DECISION DELEGATED TO HEAD OF PLANNING

Application No: H08-1023-25 **Applicant:** Mr D Charlton

Proposal: Residential Development comprising 1 new dwelling and conversion and extension of existing agricultural building, demolition of existing agricultural building and proposed new farm access track

Location: Risegate House Farm Hedgefield Hurn Gosberton Risegate

PROPOSED GROUND FLOOR PLAN
 1:100

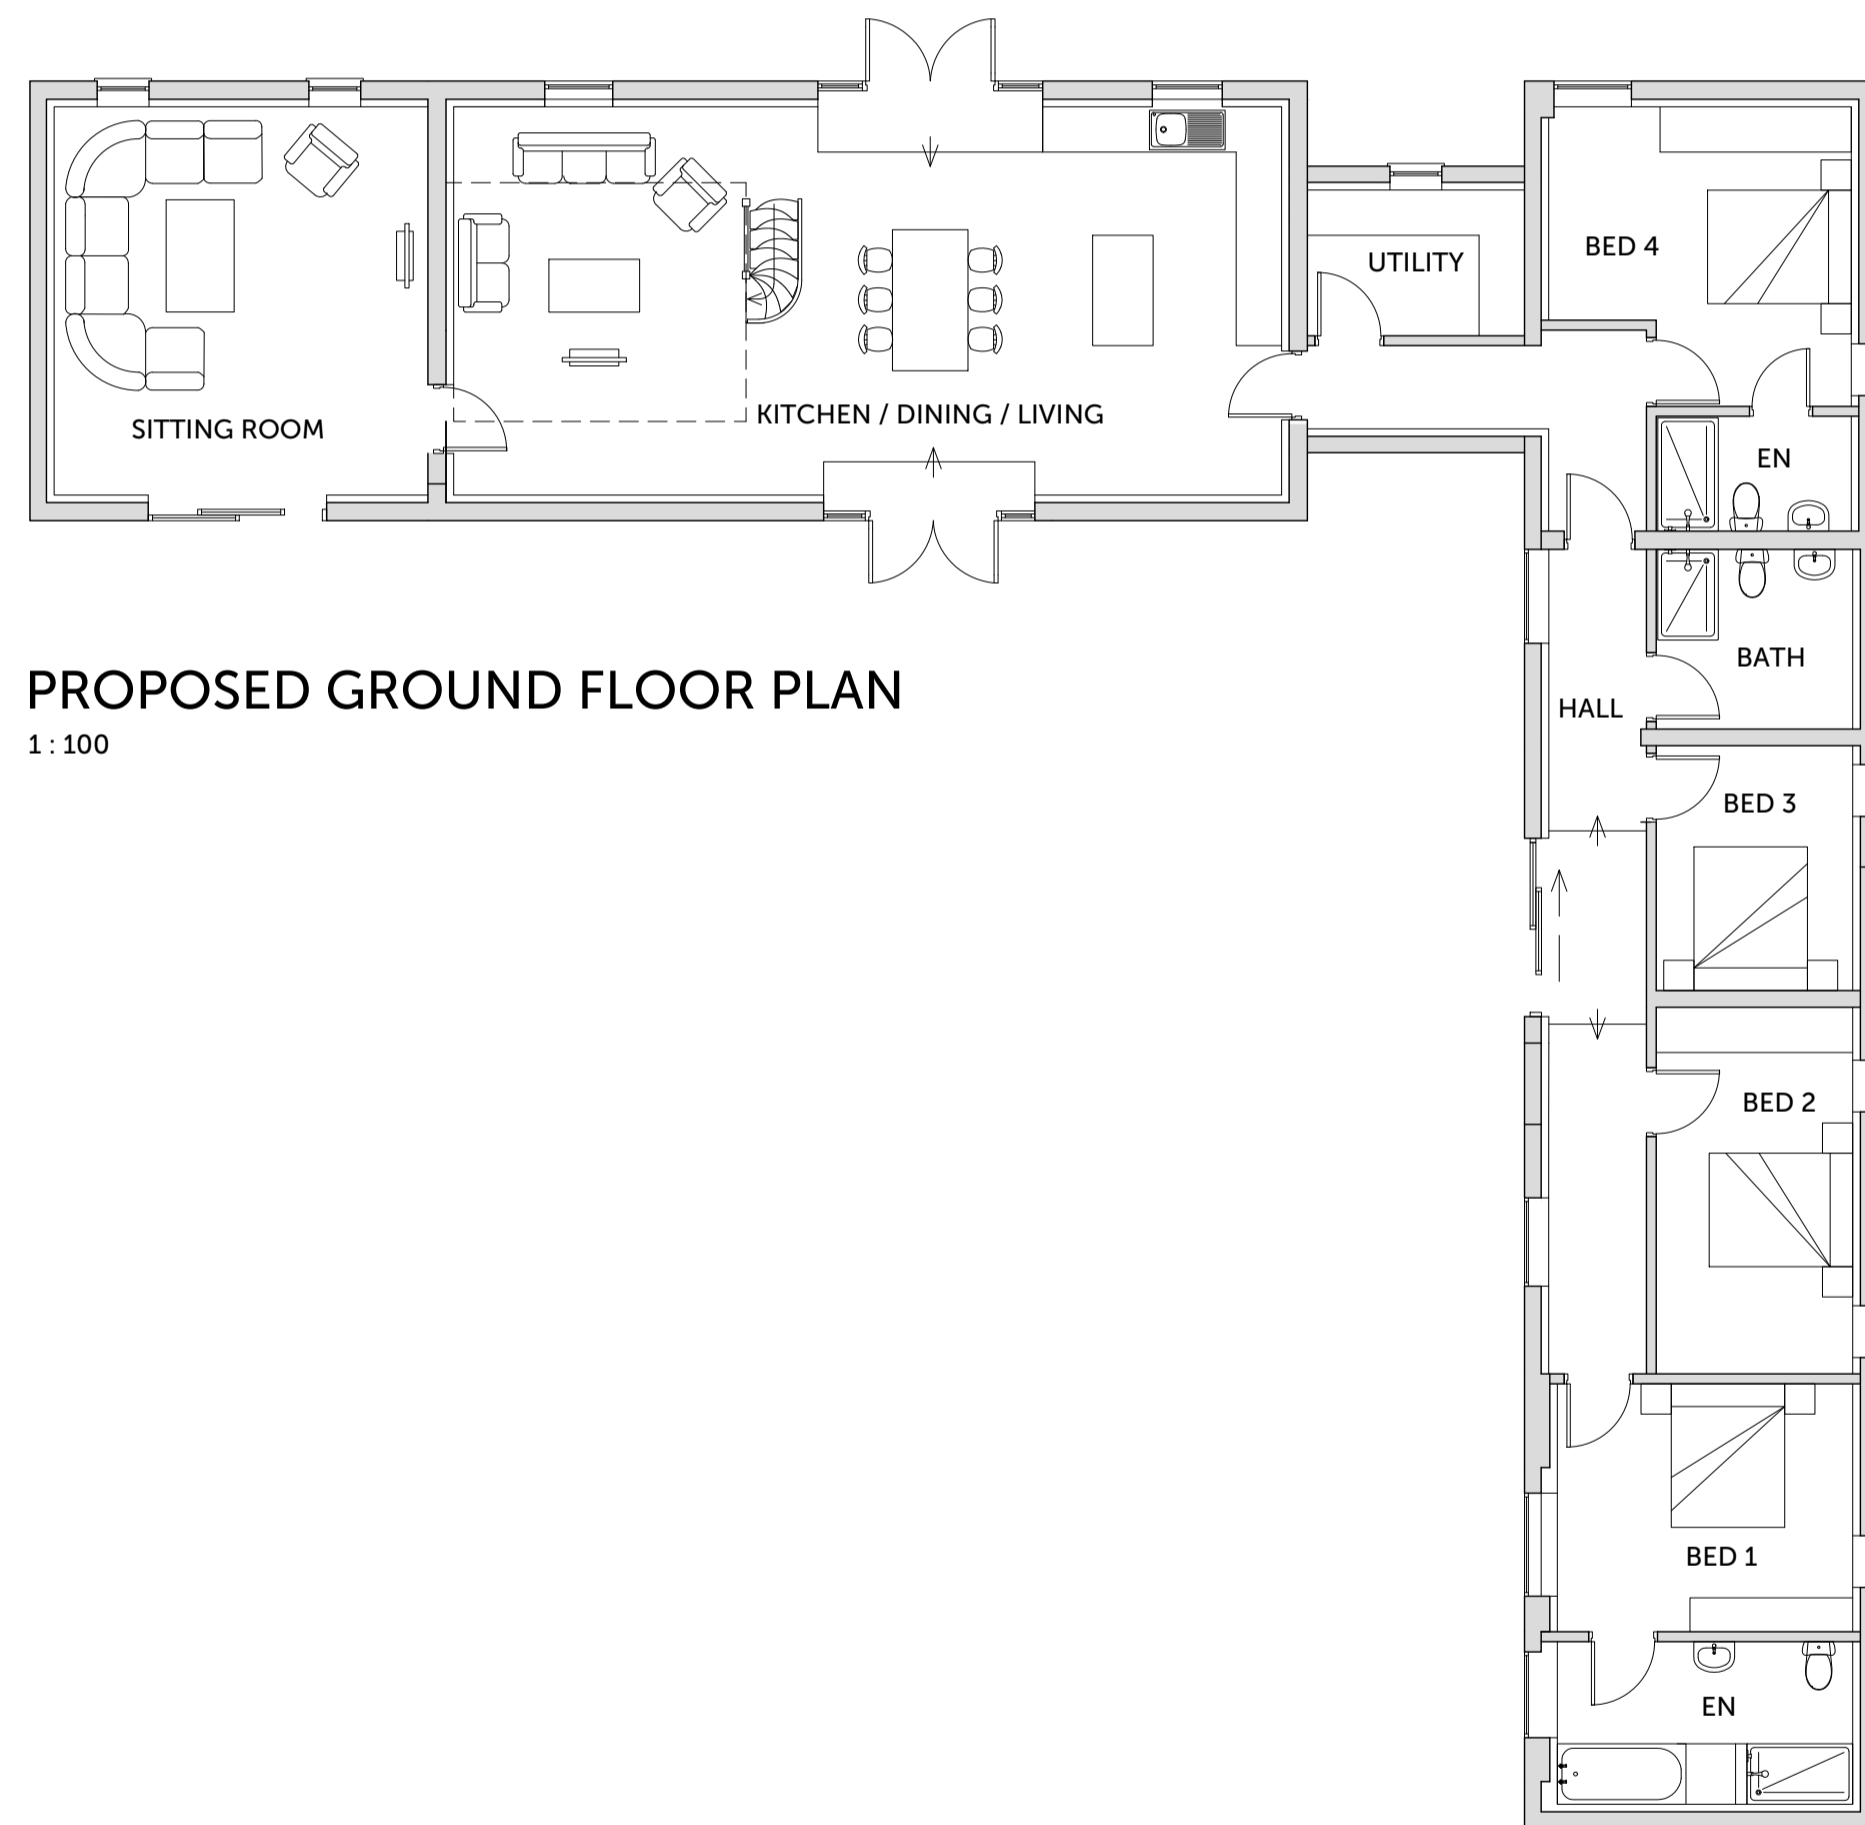
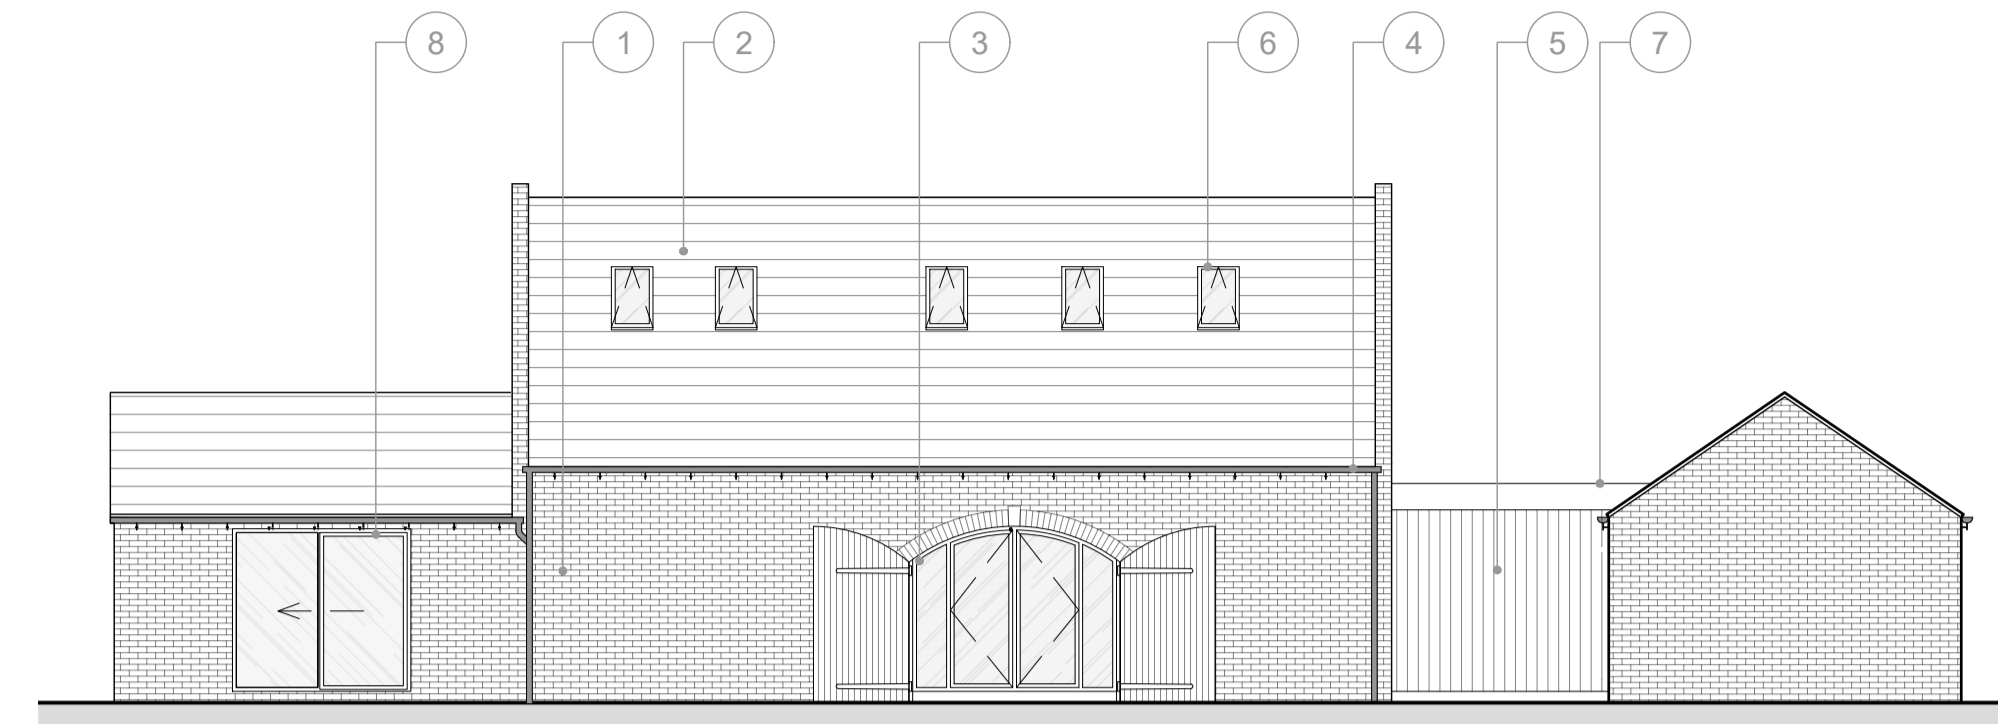
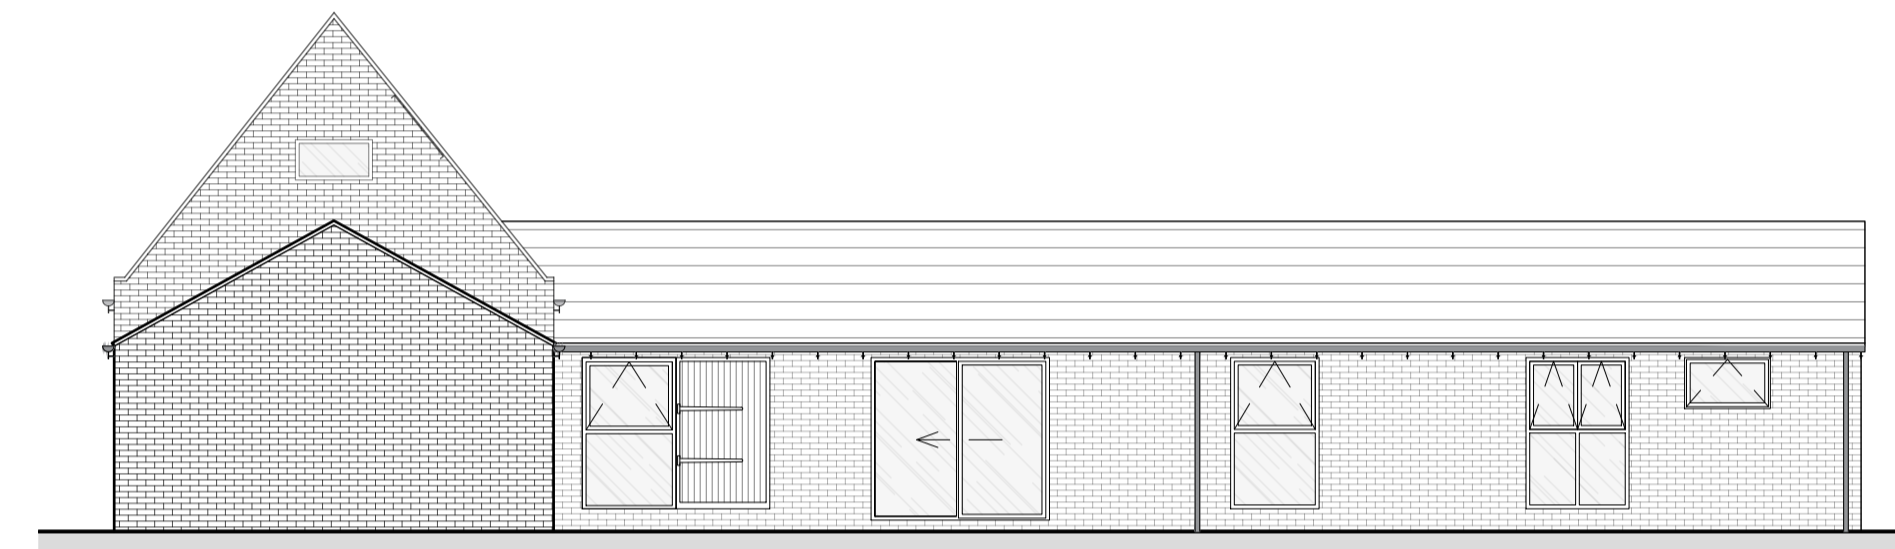
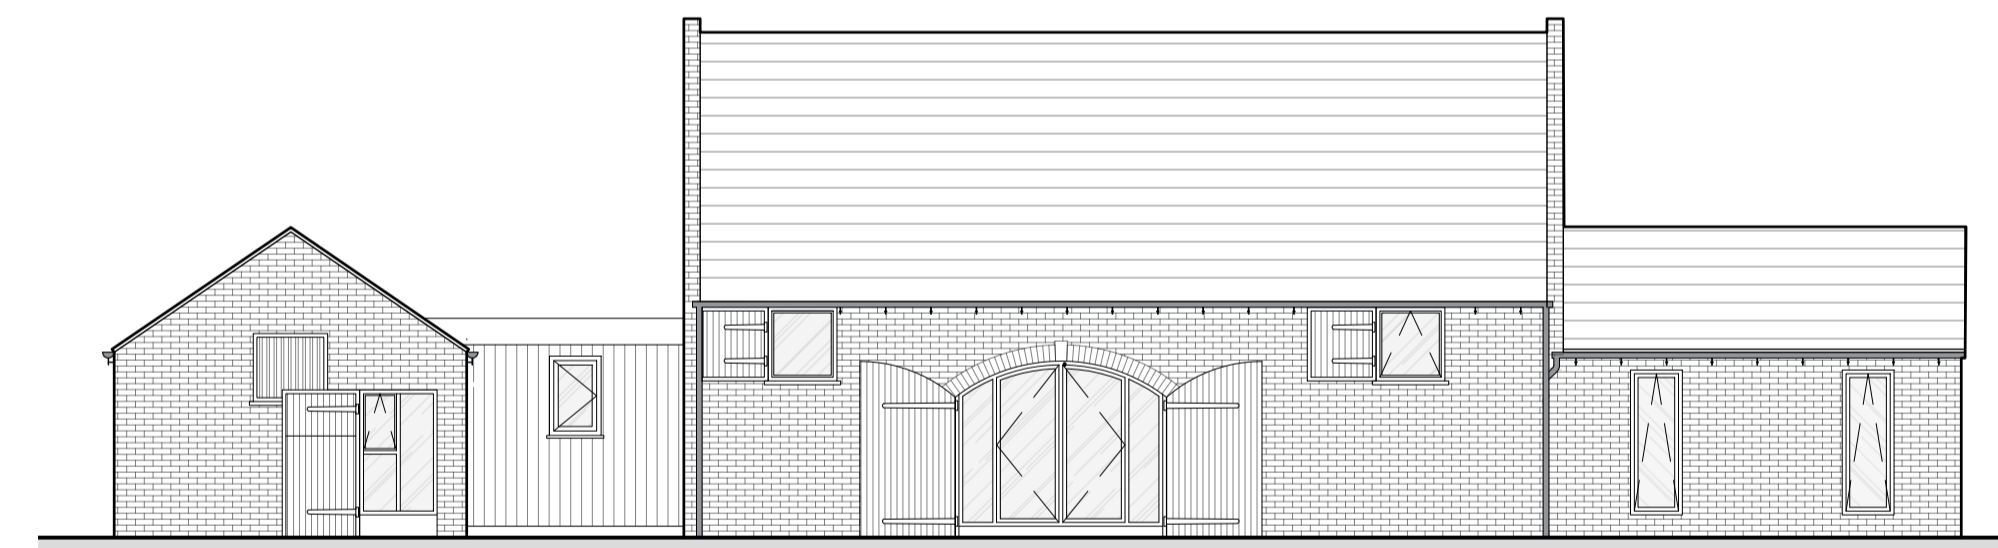
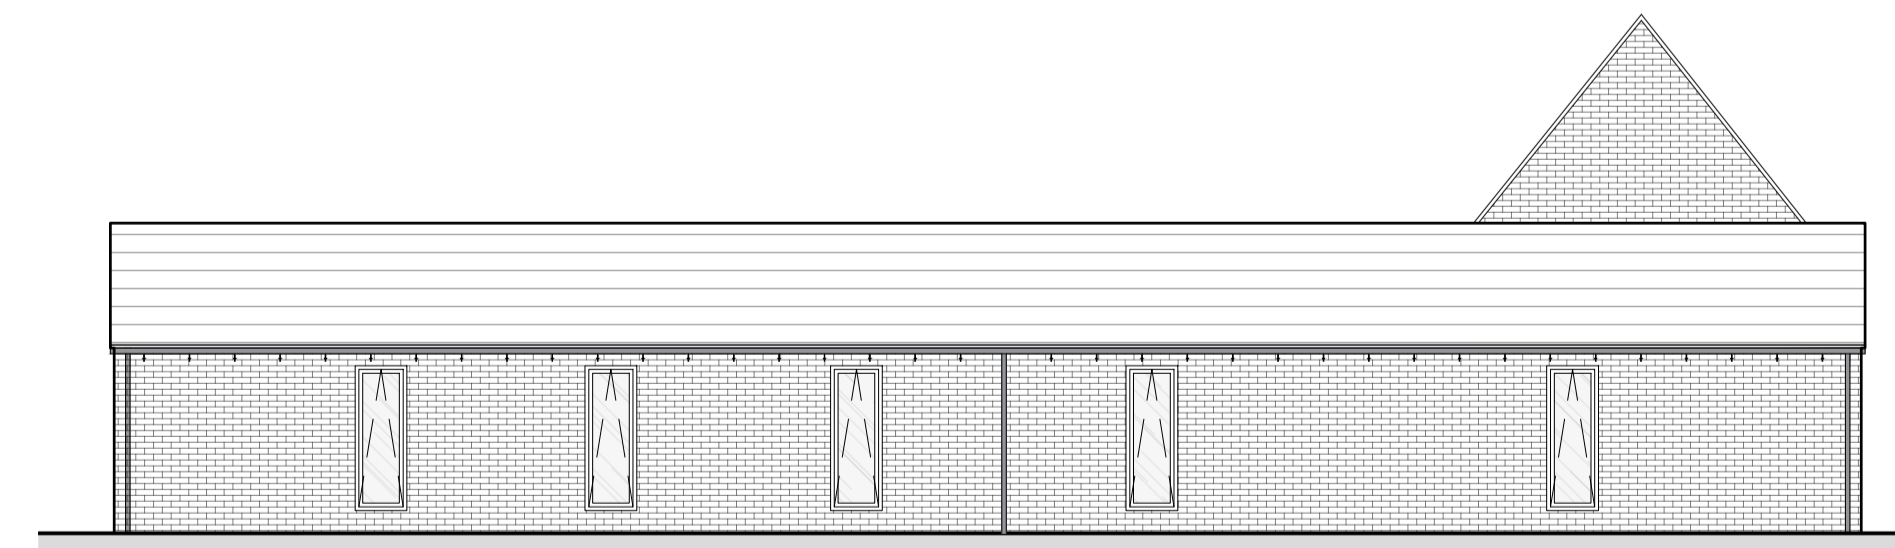
- A part of the eastern section of the northern building is proposed to be demolished. This area measures approximately 4.8m by 3.9m.
- A flat roofed extension is proposed between the south-western building and the northern building measuring approximately 2.8m by 3.9m. This element is proposed to feature vertical timber cladding.
- Additional floor length windows are proposed on the northern elevation of the northern building.

It is considered that the proposed conversion of the buildings to form plot 1 would accord with the above referenced criteria. For example, only a small-scale single storey extension is proposed to link the two buildings for the form the dwelling. The extension is not considered to be significant, nor is it considered that any of the other external changes would result in significant building alterations, in accordance with part 1 of the policy. The building is considered to be a NDHA and as such the building is considered to have historic merit, in accordance with part 2. The proposal is considered to be in keeping with its surrounding and to contain a sympathetic design that is supported by the LPA's conservation officer, in accordance with parts 3, 4 and 5. As such, the proposal for plot 1 is considered to accord with Policy 23. It is considered appropriate to remove certain permitted development rights, as is allowed for by Policy 23 in the interests of preserving the character of the building.
